Comment to planning proposal ref: PO/6/22/HH

9 June 2022

We reside at Slate Cottage, the property immediately adjacent (north west) of the proposal site, St John's Cottage.

With regard to the revised planning application PO/6/22/HH, the latest proposal does not consider all the points of concern relative to the development of Historic assets and their Historic settings, as

Sheet Title
Proposed Garage Plans

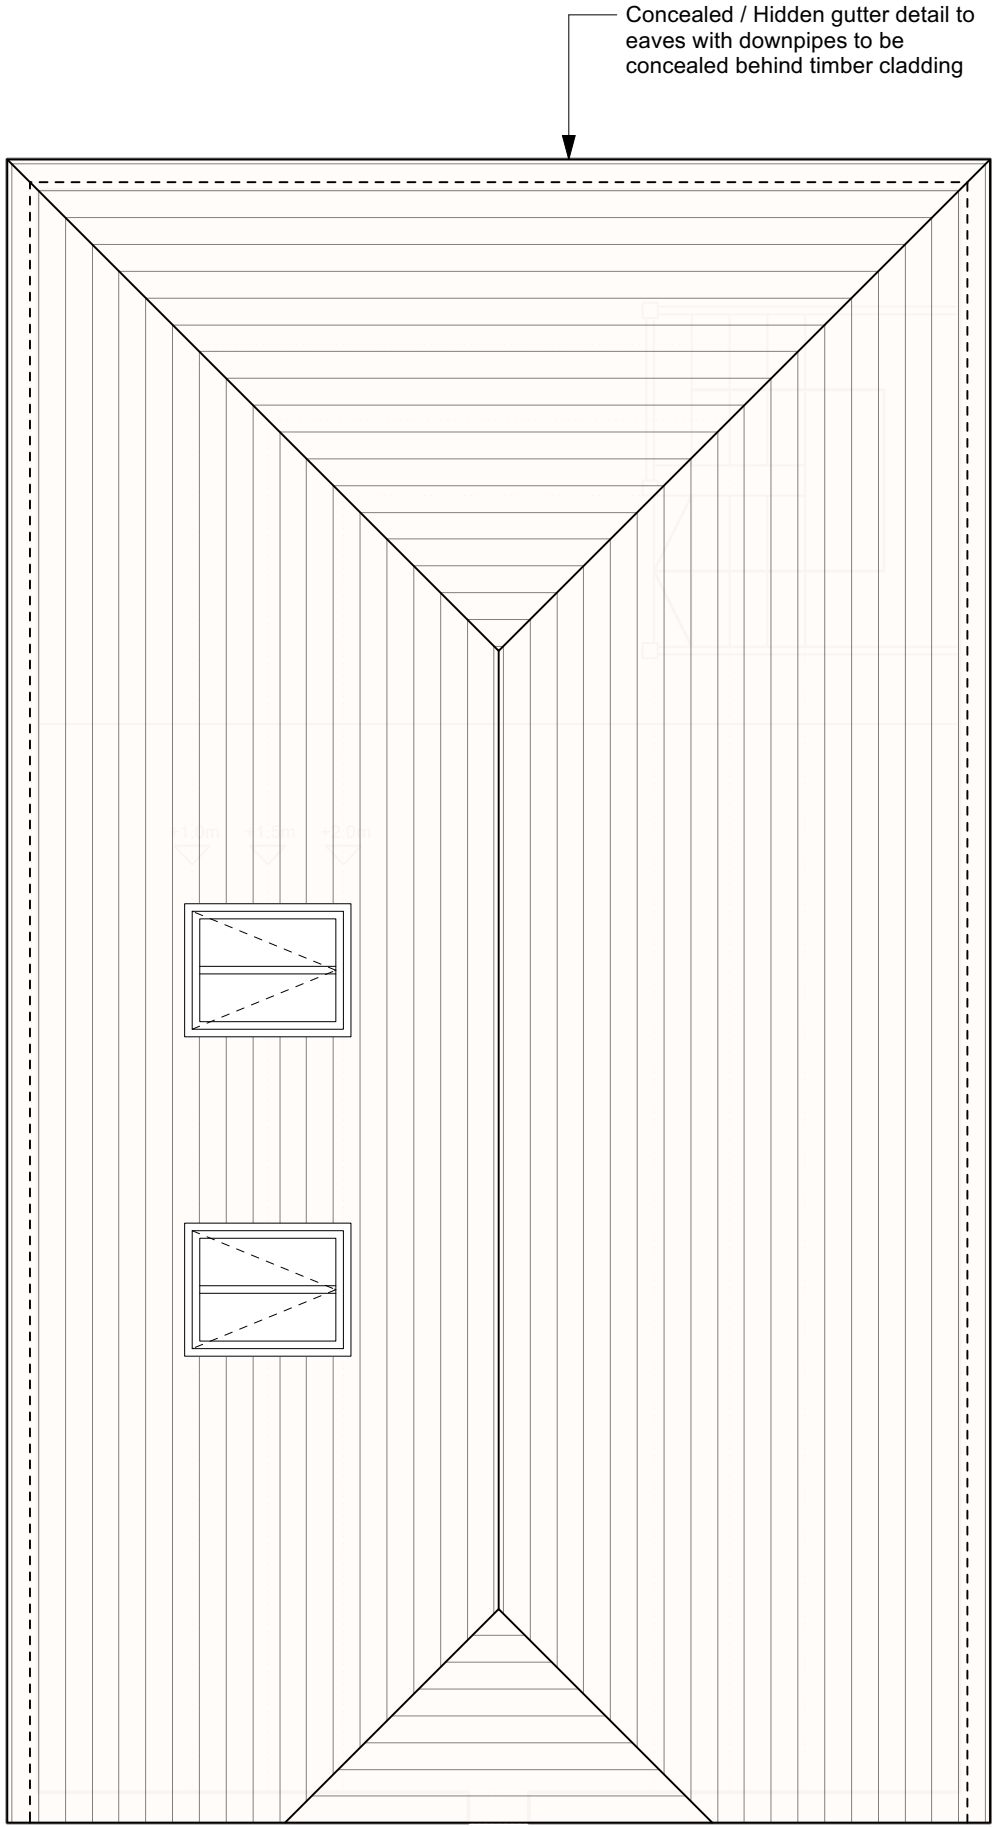
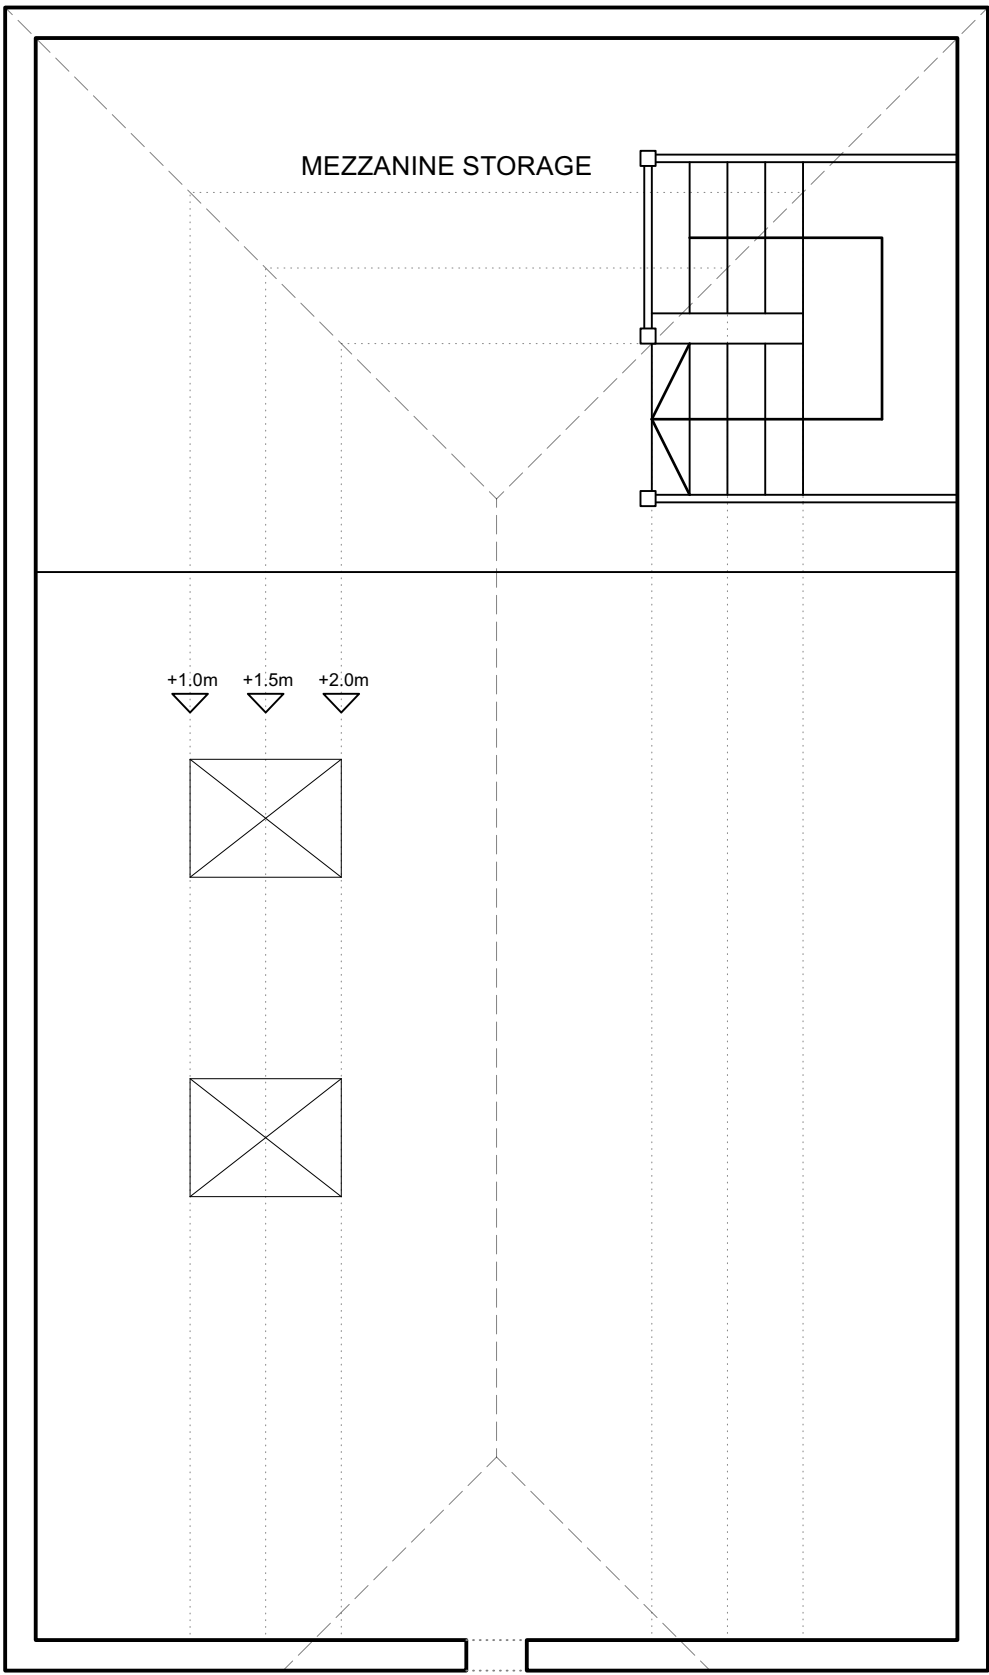
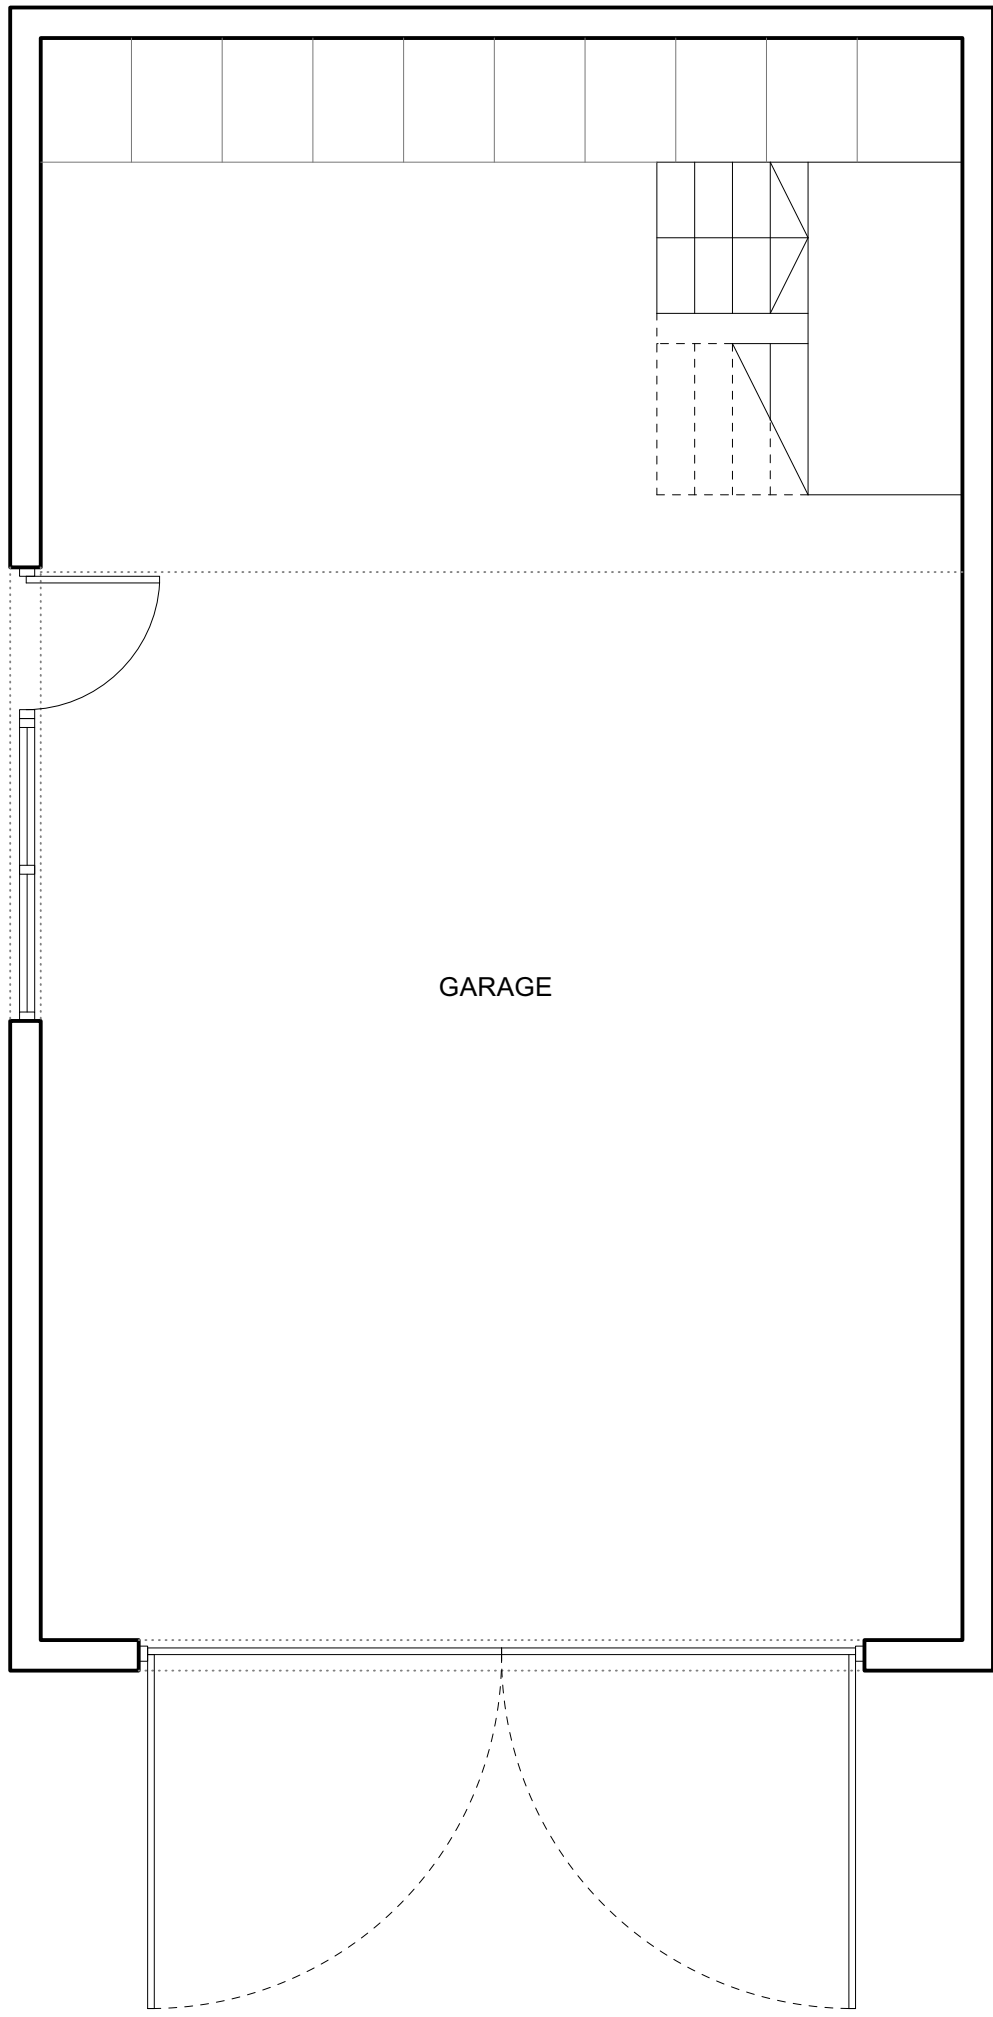
the proposal seeks to increase the built form of the current dwelling and its associated extensions and outbuildings by an amount that dwarf and dominate the original Listed Heritage Asset. The proposed garage building alone equates to a built form that is comparable in its overall mass to a small chalet bungalow and comparable to the footprint of the original Listed Cottage. It appears as an alien form in this setting when viewed against the Heritage Asset.

For these reasons it is difficult to see how the proposed mass of both the Garage building and the side/rear extension can be viewed as subservient to the existing Heritage Asset.

St John's Cottage needs restoration and we would support any renovation work and development sympathetic and protective of its historical asset status and its special heritage setting. However, the new proposal still seeks to enlarge this historical site with an overbearing extension and garage. From the block plan, the extension alone seems to take up a footprint that would be similar to a detached dwelling in its own right and is little changed in mass and scale from that of the withdrawn proposal and therefore cannot be described as subservient to the Historical host dwelling.
